Reply To: address as below
Our Ref: 6/2017/1327/COND
Direct Tel: 01707 357211
Fax: 01707 357253
Email: planning@welhat.gov.uk

9 August 2017

RE: 6/2017/1327/COND – Submission of details pursuant to conditions 2 (parking, cycle & bin storage) and 5 (cycle storage) on planning permission 6/2016/1031/FULL dated 10/11/2016 at 8 Harpsfield Broadway Hatfield AL10 9TF.

| 1 : 50 | 8AHB/R02A | |

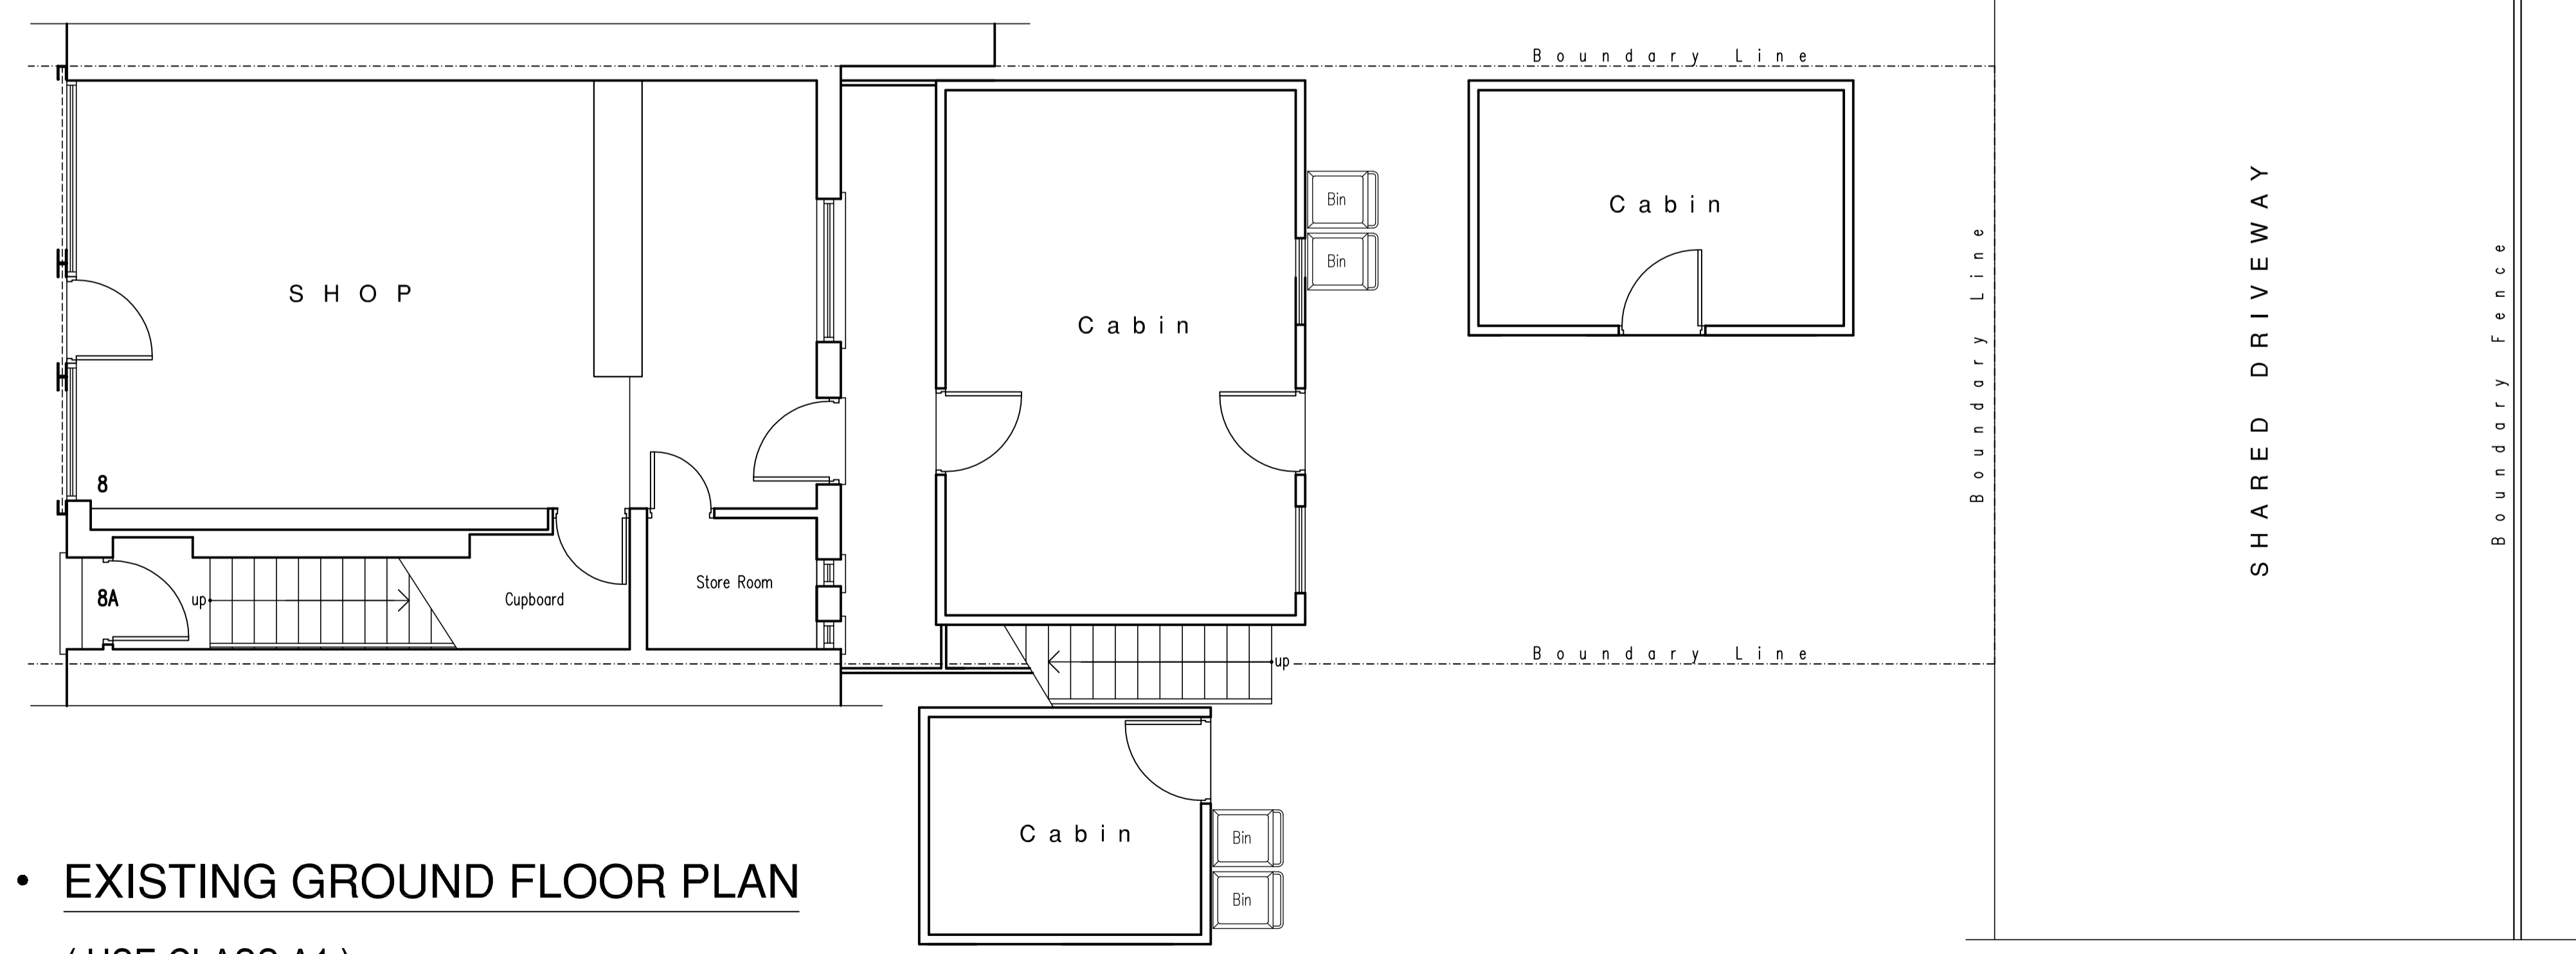
You have submitted Drawing Number 8AHB/R02A. This block plan shows the car parking layout, cycle store location and bin storage area in the same layout as in Drawing 8HB/P03 referred to in the above condition. In addition this plan identifies the hard landscaping materials to be used.

Welwyn Hatfield Borough Council's Client Services was consulted and has no objection. They comment that the bins can be serviced from the rear access road. The HMO will be given 1 refuse bin and 1 recycling bin which will be emptied alternate weeks. There needs to be sufficient room for the residents to wheel the bins to the collection point (where the parking bays meet the rear access highway).

The Highways Authority has also been consulted and considers the submitted plan to be acceptable.

The details submitted are, therefore, acceptable pursuant to Condition 2. I trust you will comply with the condition, which requires the development to be carried out in accordance with the approved details and maintained.

| Rev. | Date | Description |
|---------------------------------------------------------------------------------------------------------------------------------------------------------------|---------------------------|-------------|
| Scale 1 : 20, 1 : 10 | Dwg No 8AHB/R03 | |

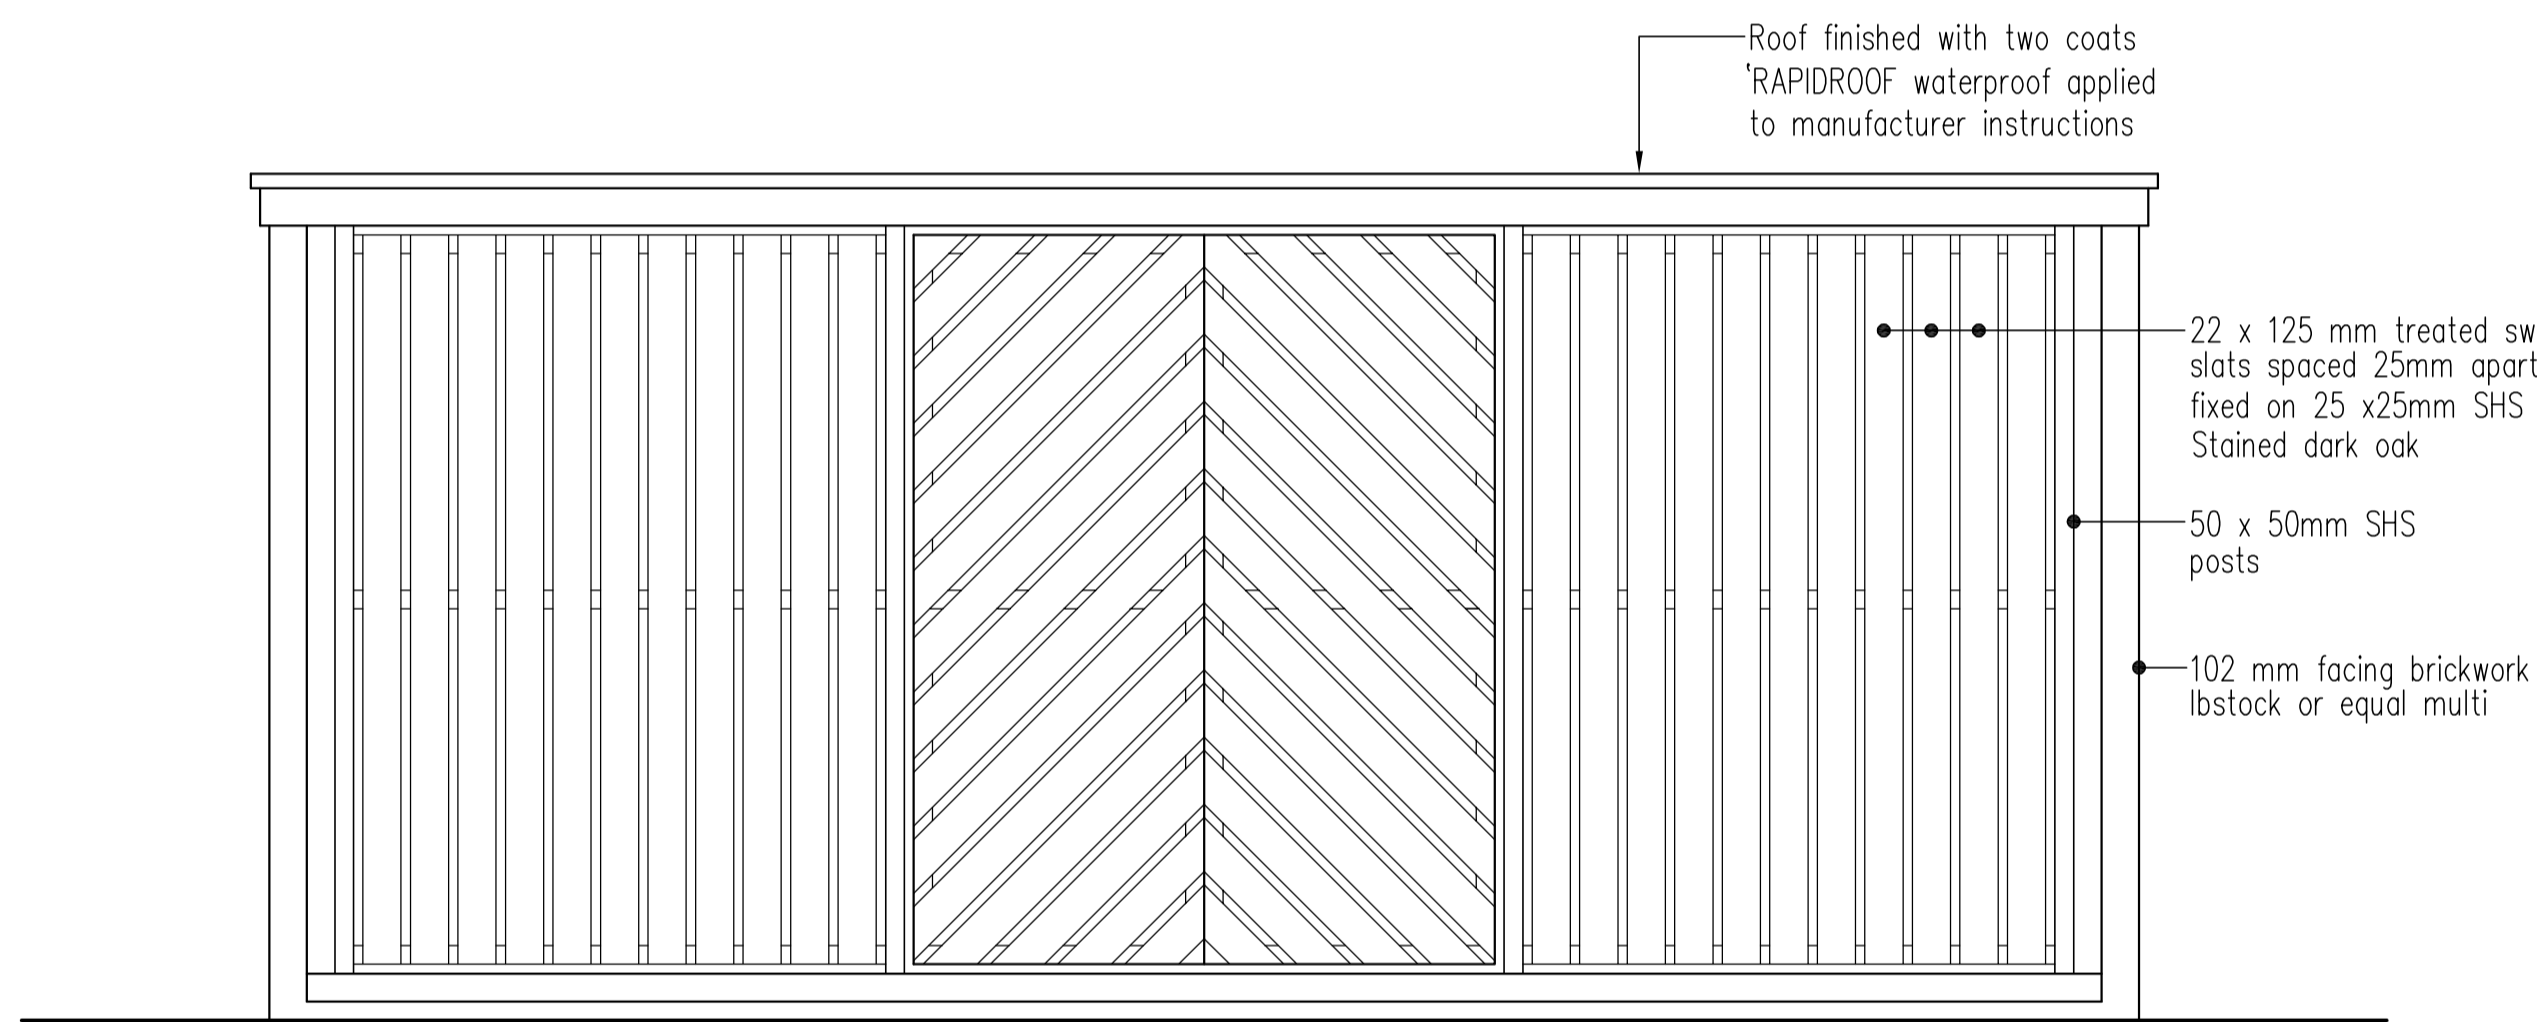
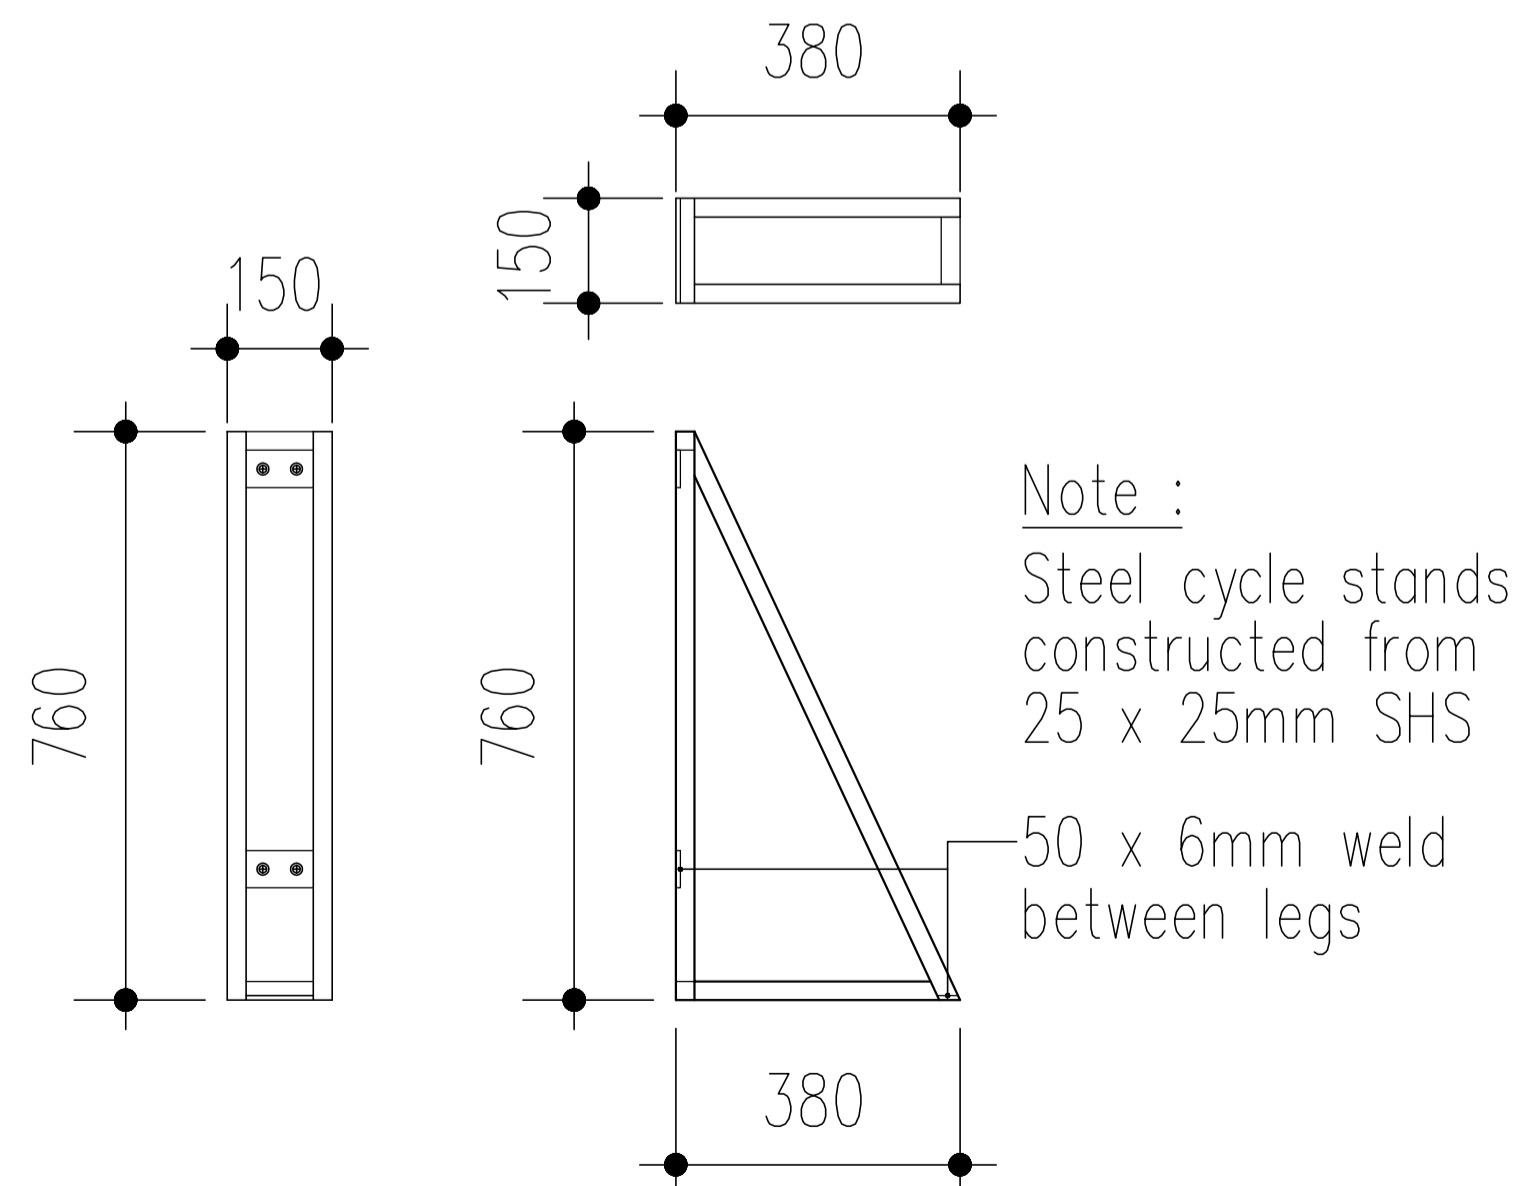
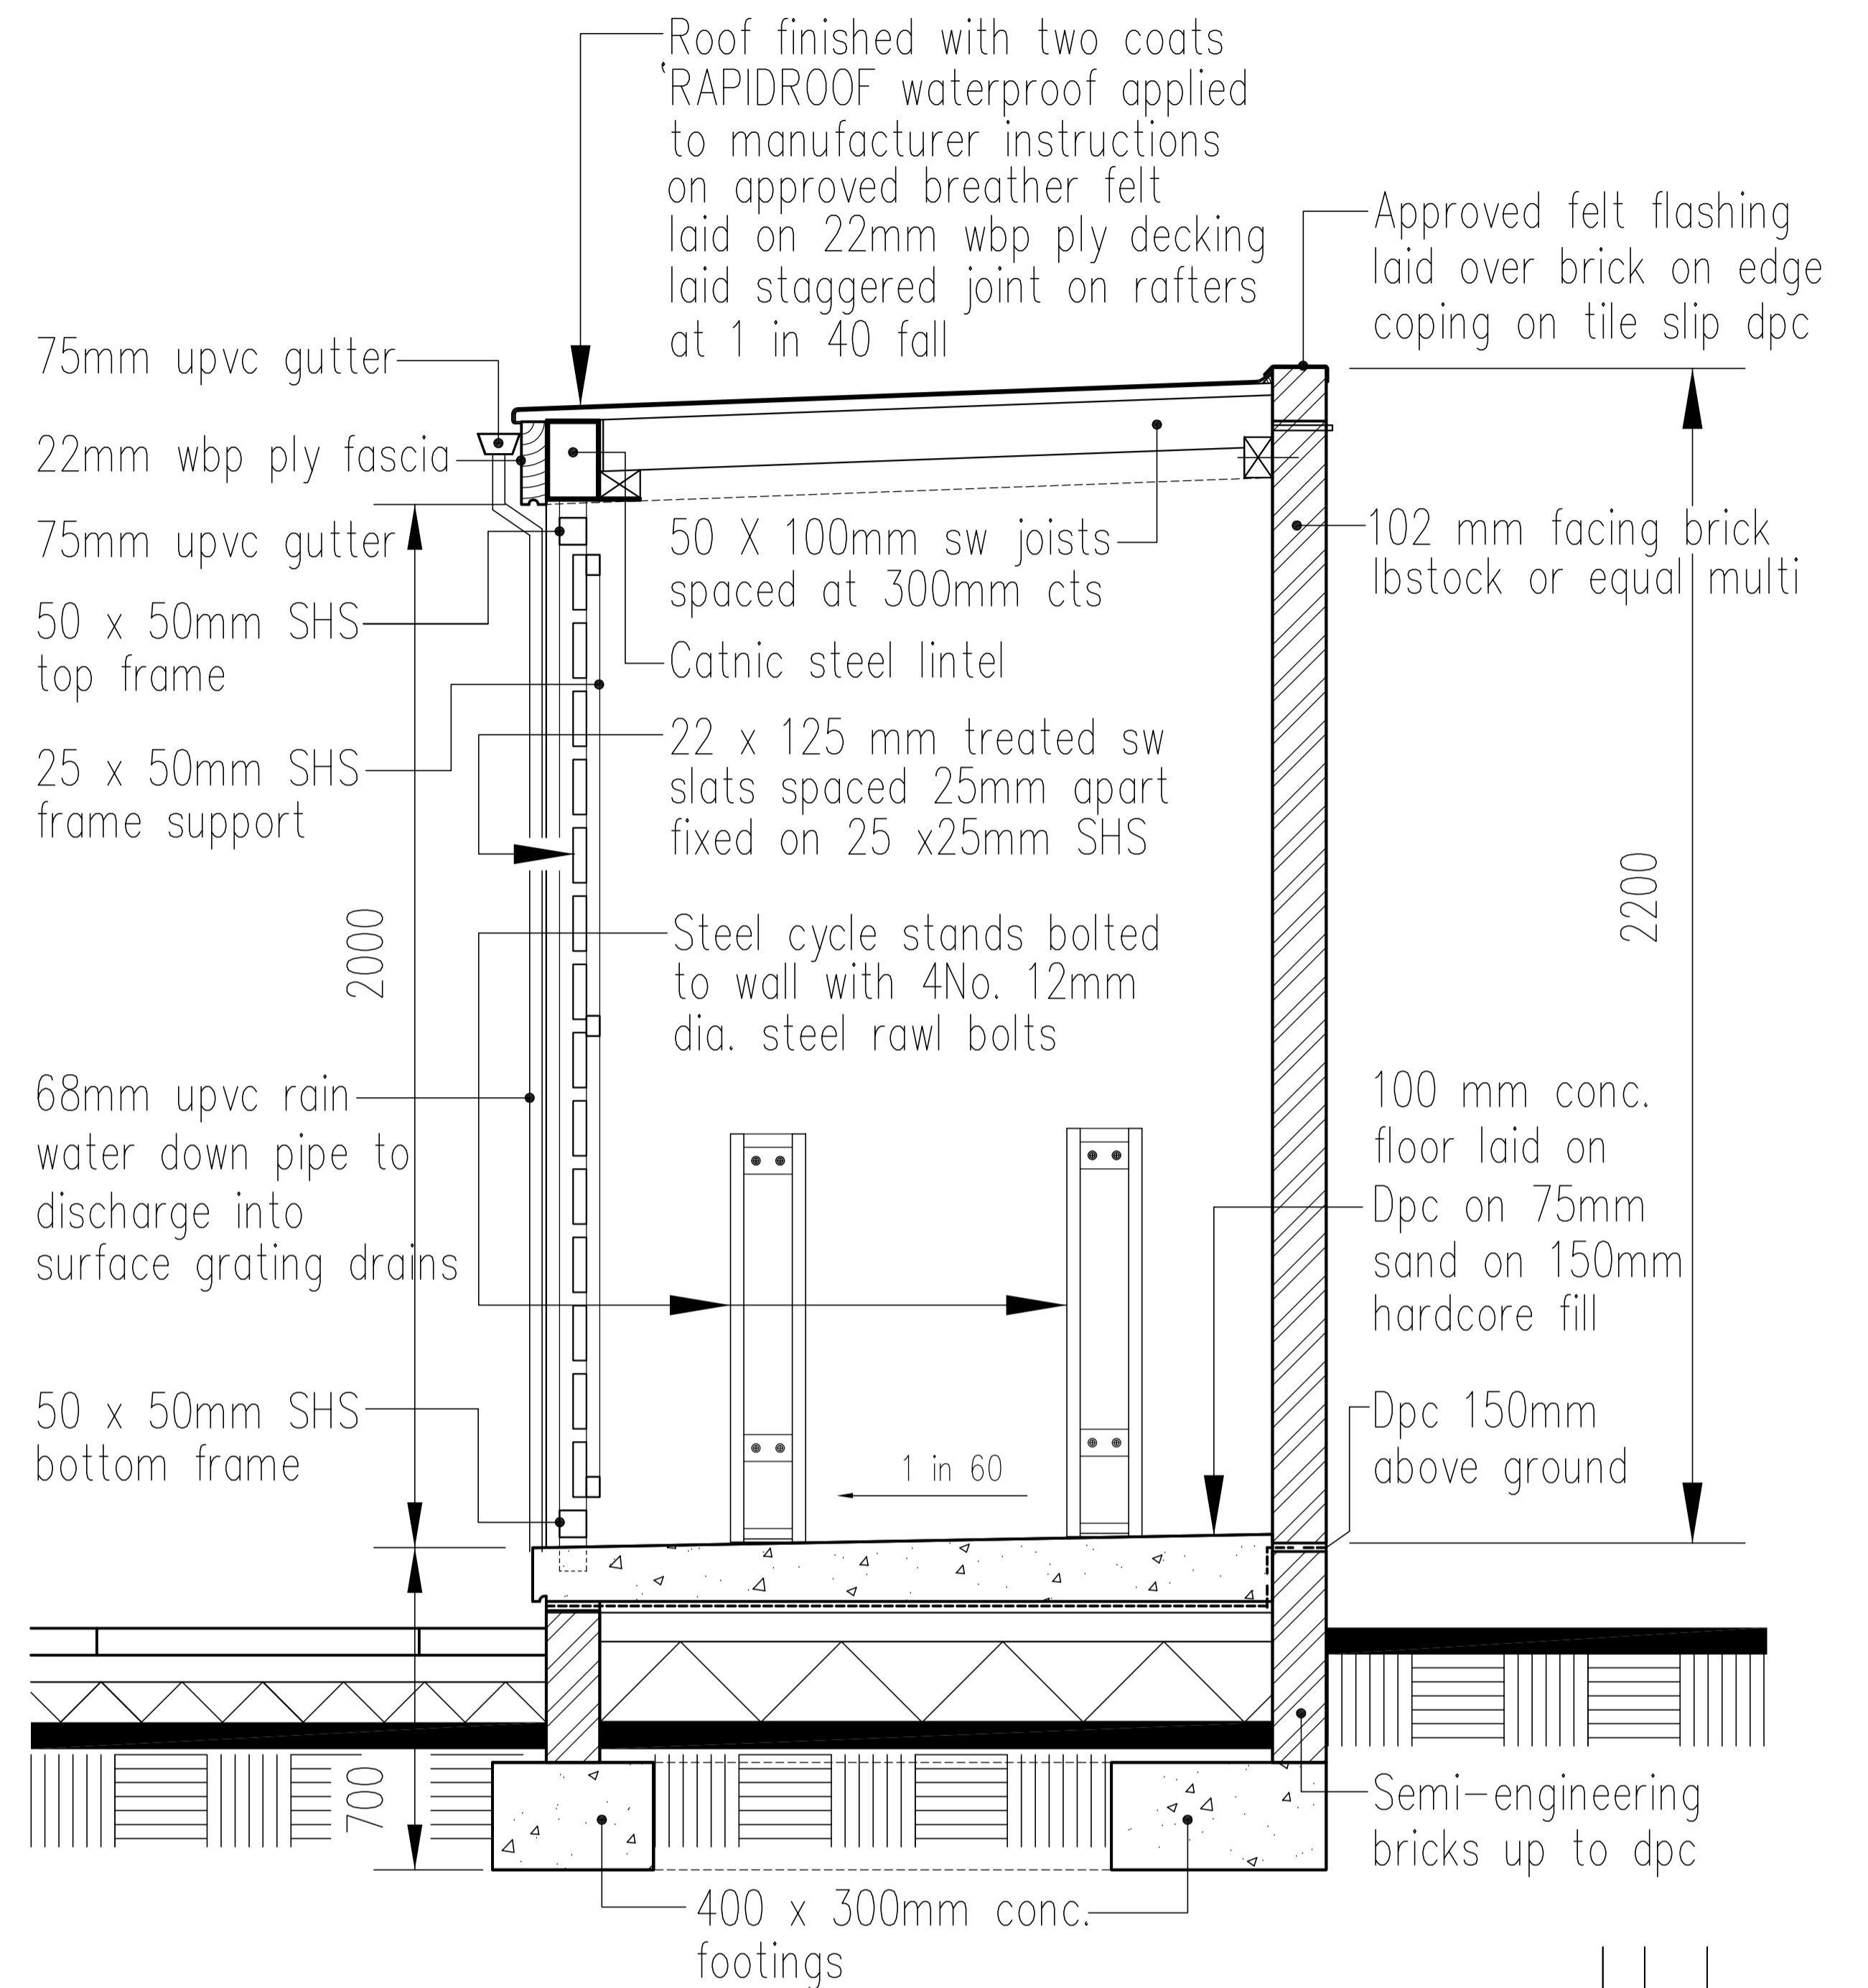
Proposed Cycle Store Details Drawing number 8AHB/R03

The Highway Authority has been consulted and considers the submitted plans to be acceptable.

The details submitted are acceptable pursuant to Condition 5. I trust you will comply with this condition, which requires the development to be carried out in accordance with the approved details and retained.
